RE: 657-703 Mamre Road, Kemps Creek (SSD-9522) Modification 2 – Response to Submission - Transport Statement

TABLE 1: RESPONSE TO TFNSW'S COMMENTS

Figure 8: SIDRA Network Layout for Approved Modified Sequence 1A (modelling years 2025, 2026, 2031 and 2036)

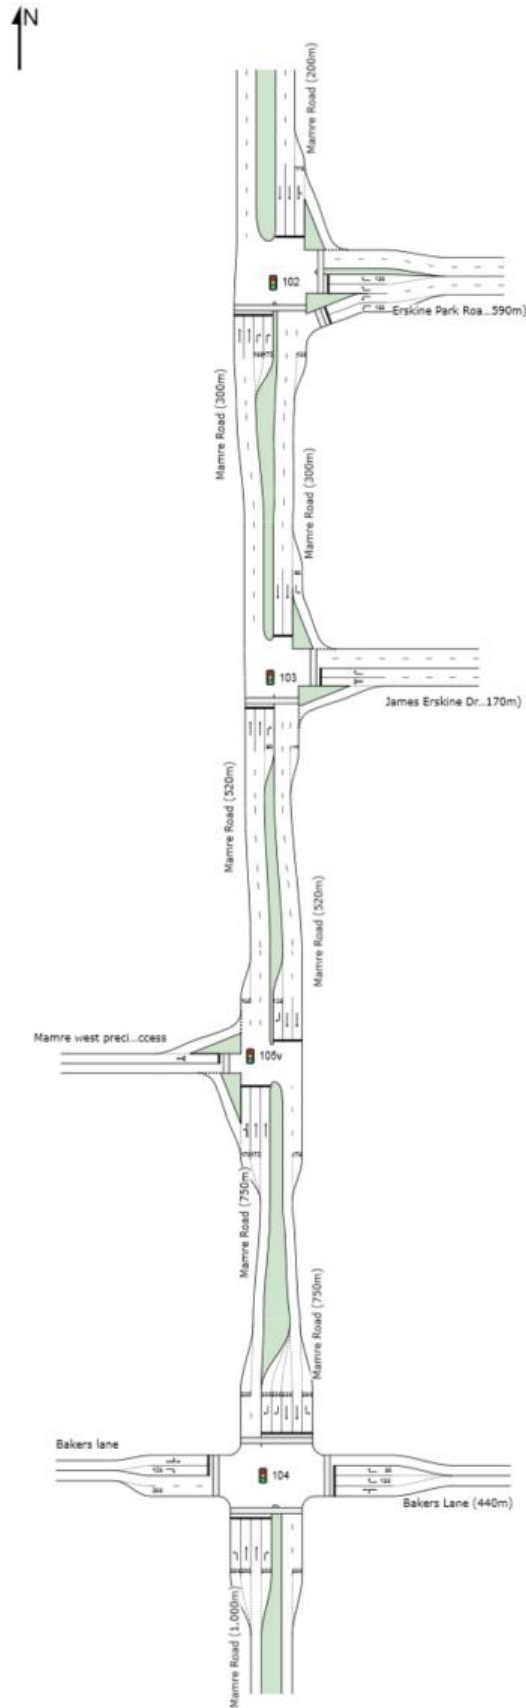
16	<p>ii. Appendix 8 – TIA (P1780r01v7 TN_Kemps Creek SSD 9522 MOD 2)</p> <ul style="list-style-type: none"> The SIDRA Network layout in Figure 8 appears to indicate that under Modified Sequence 1A, the section of Mamre Road between Distribution Drive (Mamre West precinct access) and James Erskine Drive is two lanes in each direction. However, the existing section is only one lane in each direction. This needs to be updated to reflect the actual lane arrangement. 	<p>It is important to emphasise that under the Stage 2 Mamre Road upgrade work, this section of the road (from Distribution Drive to James Erskine Drive) is expected to be upgraded by TfNSW (not as part of the SSD approval conditions). Hence, it makes sense to model this section as two lanes, noting future upgrades in the area. However, since the timing for the Stage 2 upgrade work has not been determined yet, we have undertaken an Option Testing to address this comment.</p> <p>Accordingly, the SIDRA Network layout has been amended to reflect TfNSW's request and the relevant movement summaries have been shown within Attachment E.</p> <p>Furthermore, as shown within Attachment E, the additional options testing indicates that Modified Sequence 1A (with one lane in both directions) operates at an acceptable LoS.</p>
